### Application for Planning Permission

**Development:** Demolition of existing tennis court and erection of a commercial building (within Use Class E(g)), parking, landscaping and other associated works. This application from the Departure Plan, affects the character and appearance of the Norton Lane, Norton Conservation Area and is in CIL Zone 3 (Zero Rated) as other development.

**Location:** Land At West Barn Old Dairy Lane Norton PO20 3AF

First Floor
540m2 GIA - 418m2 Office space

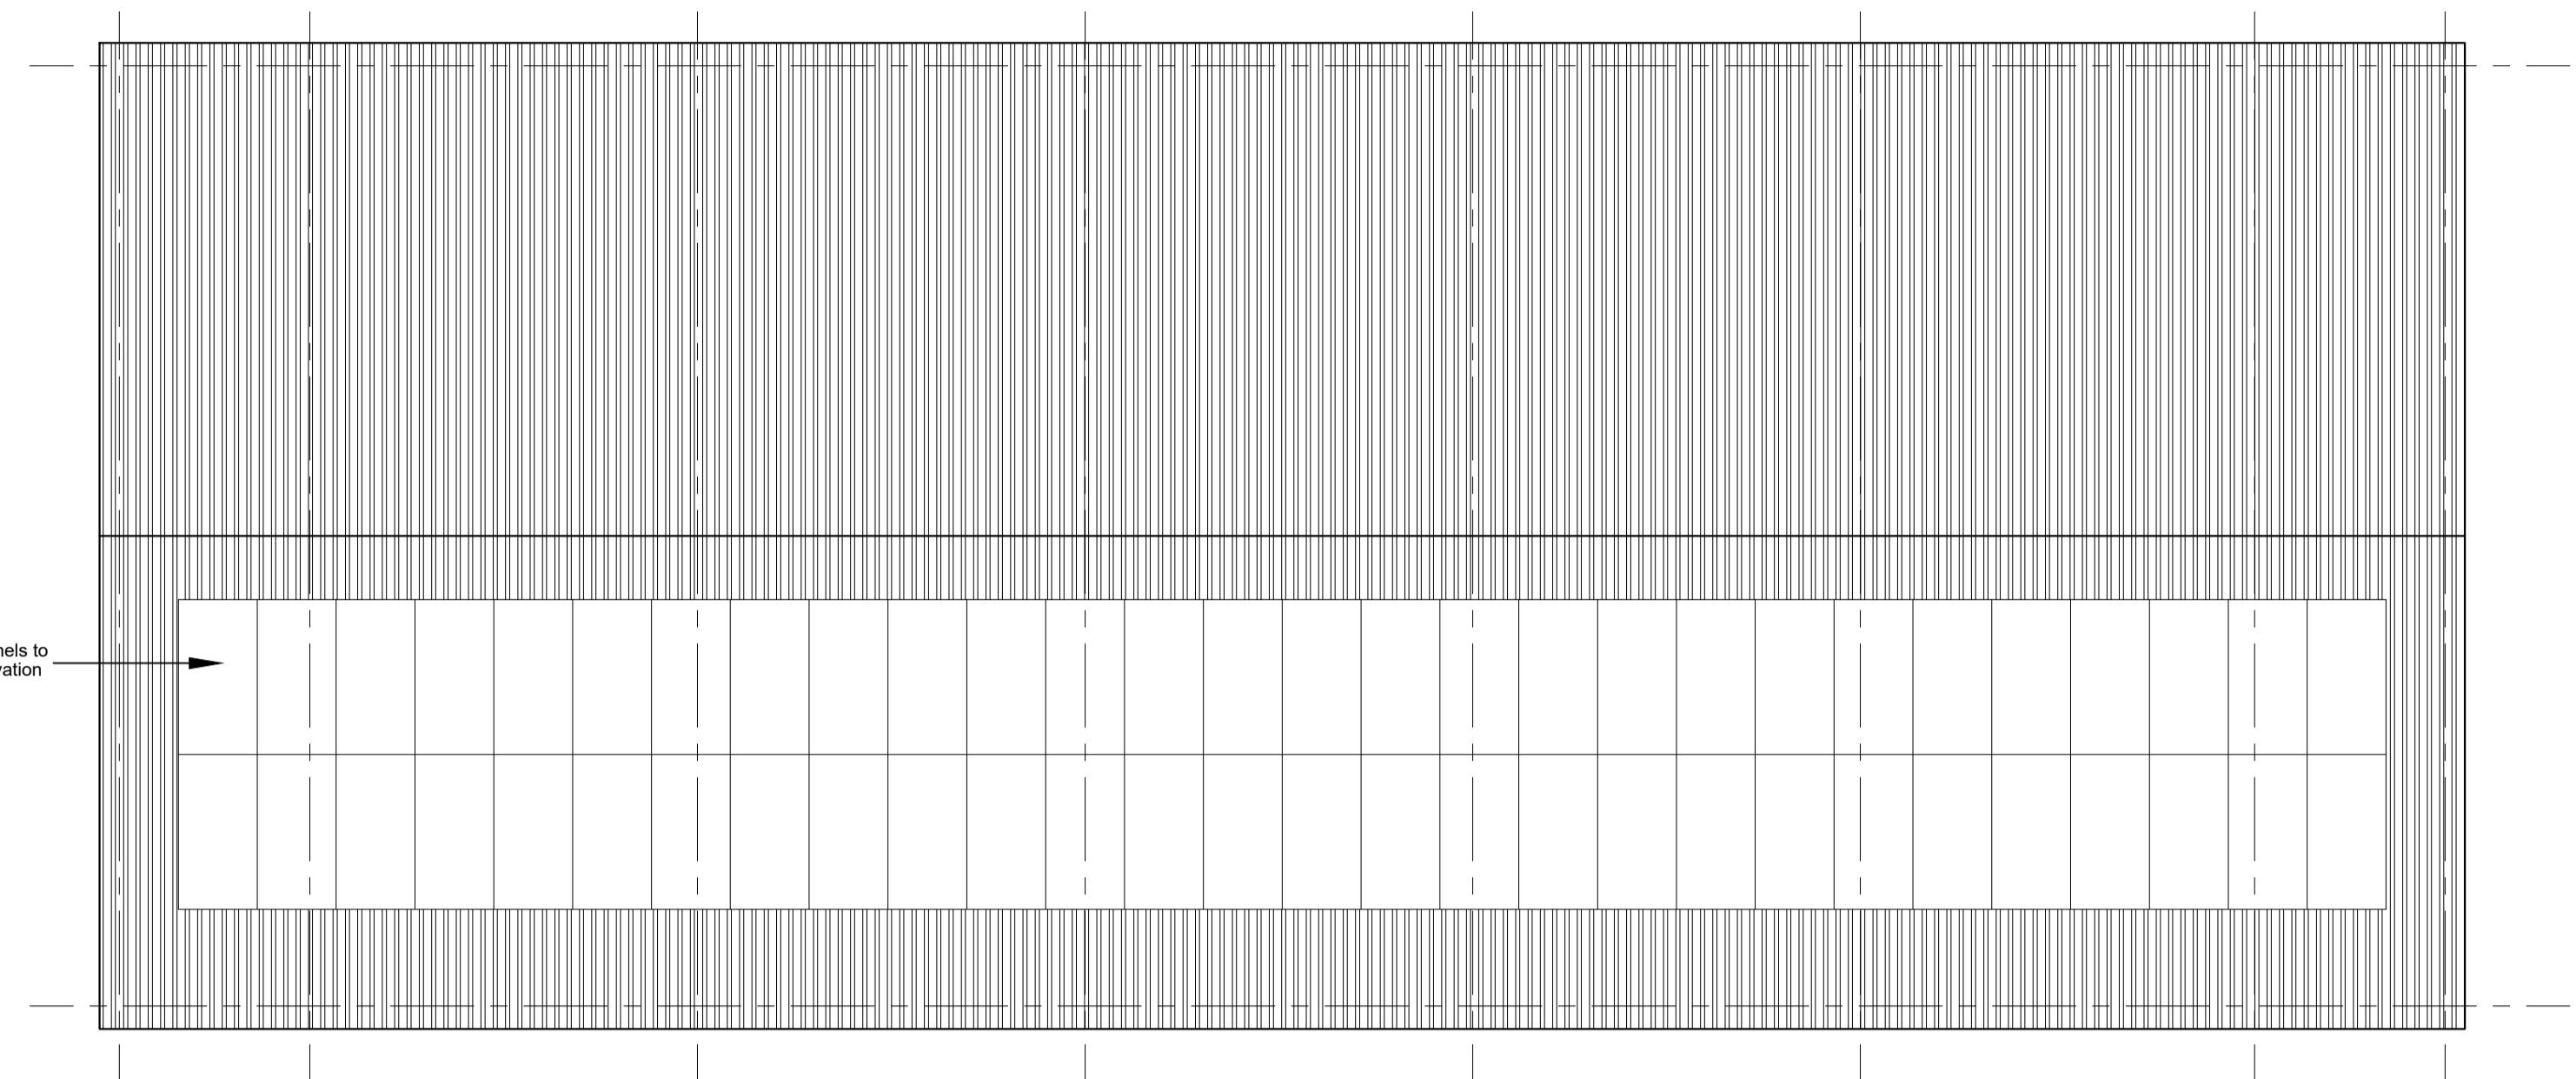
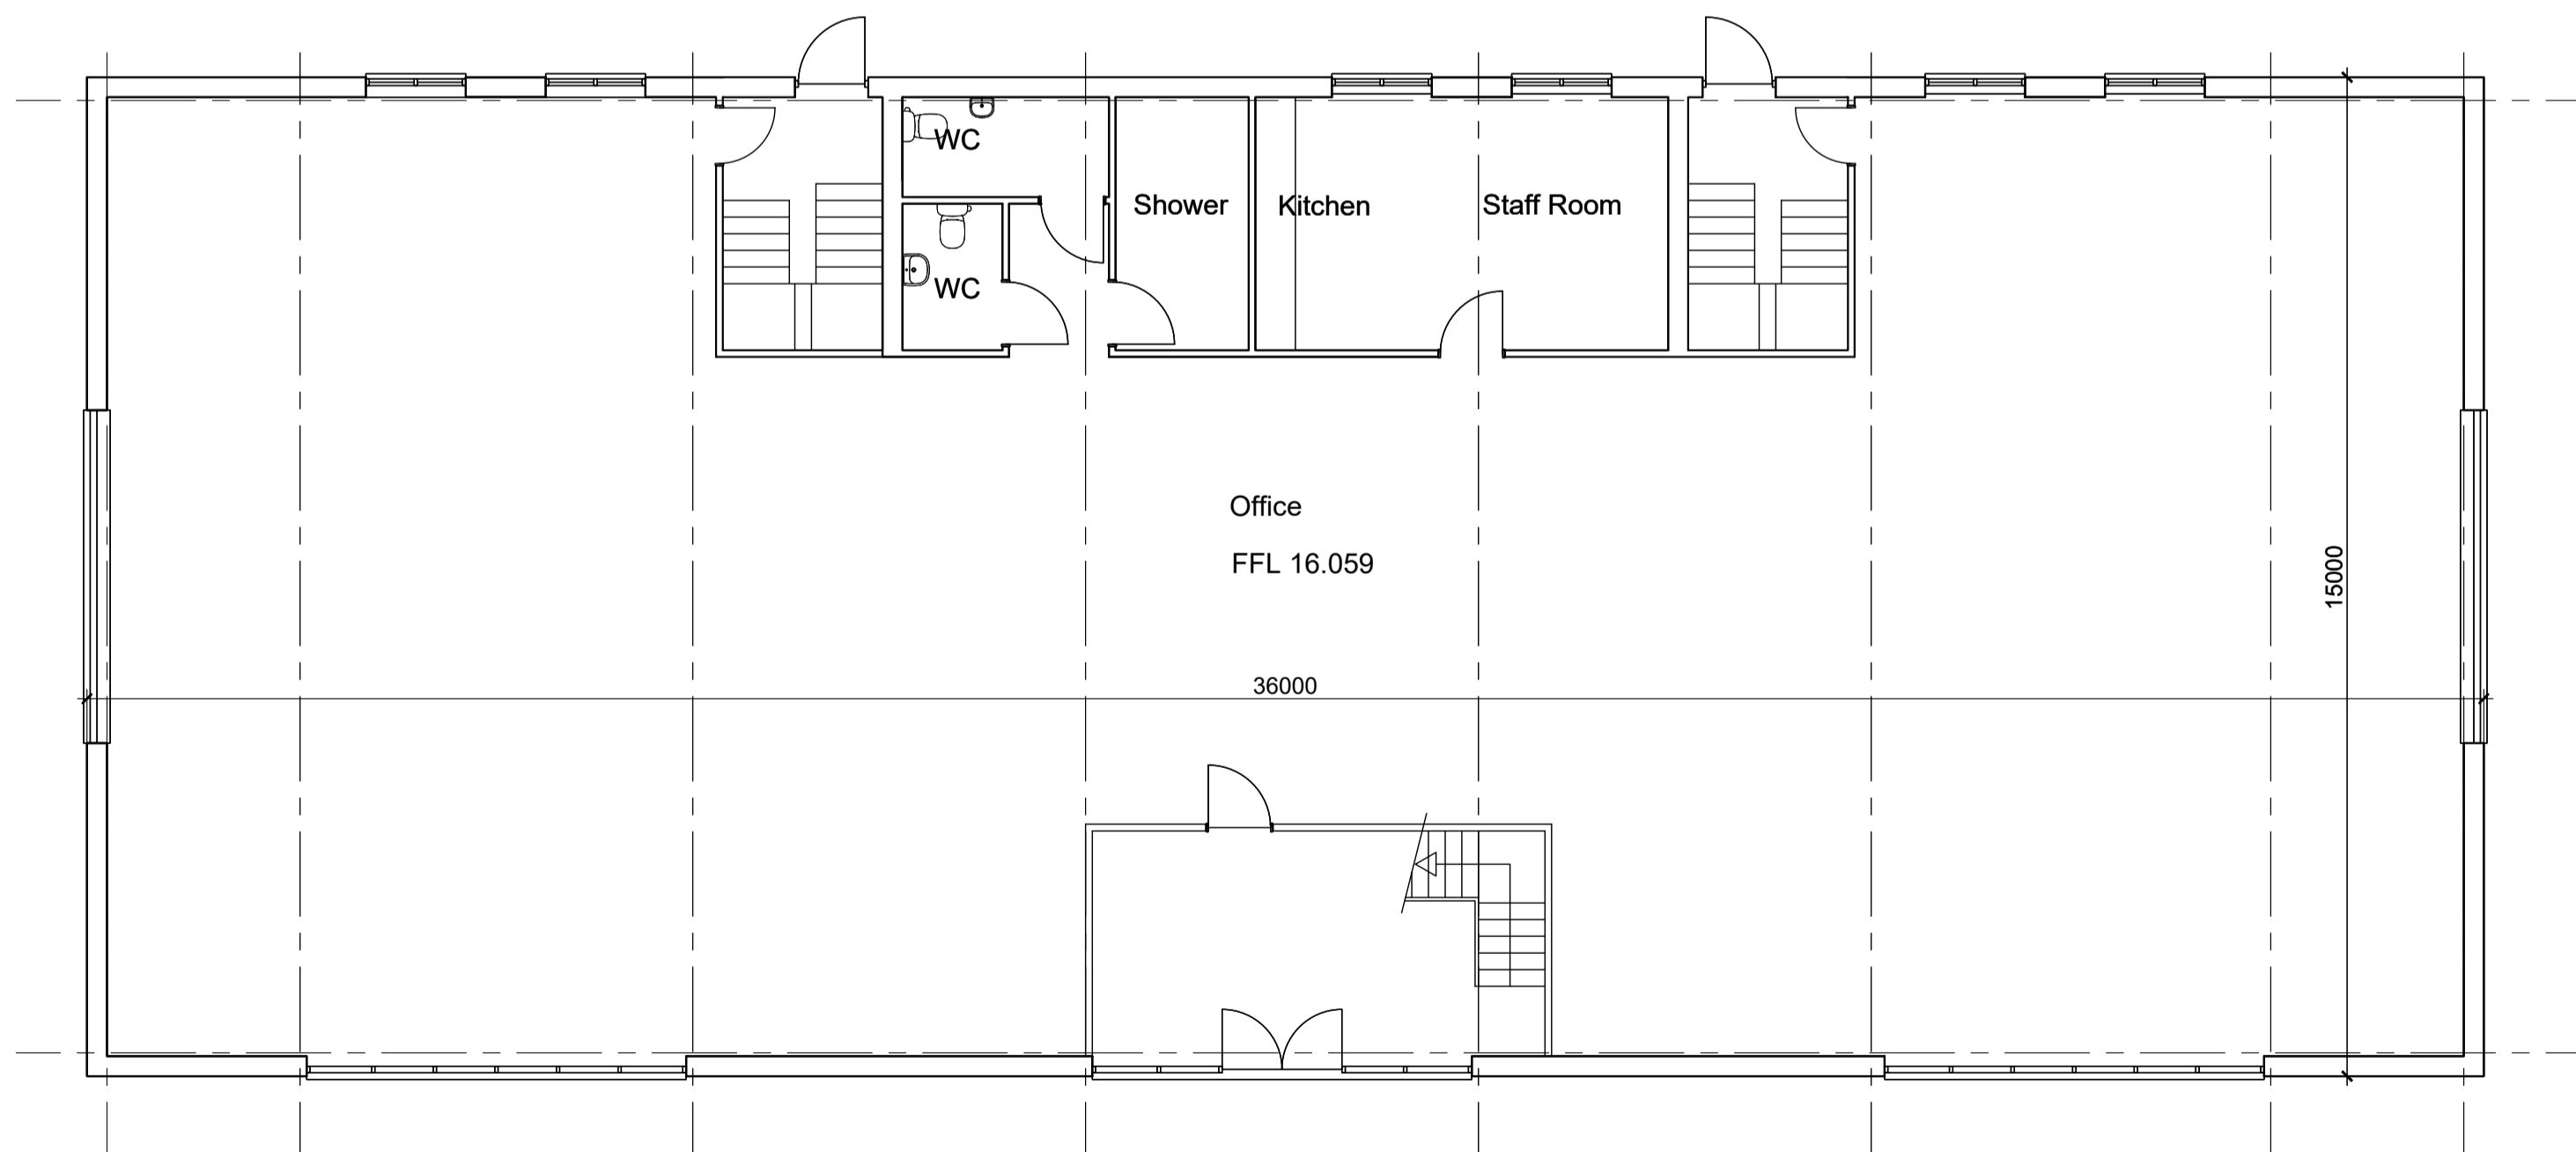
For the purpose of the fee paid, please confirm if the first floor is offices or a mezzanine floor.

The first floor plan and east elevation do not accord. Please amend accordingly.
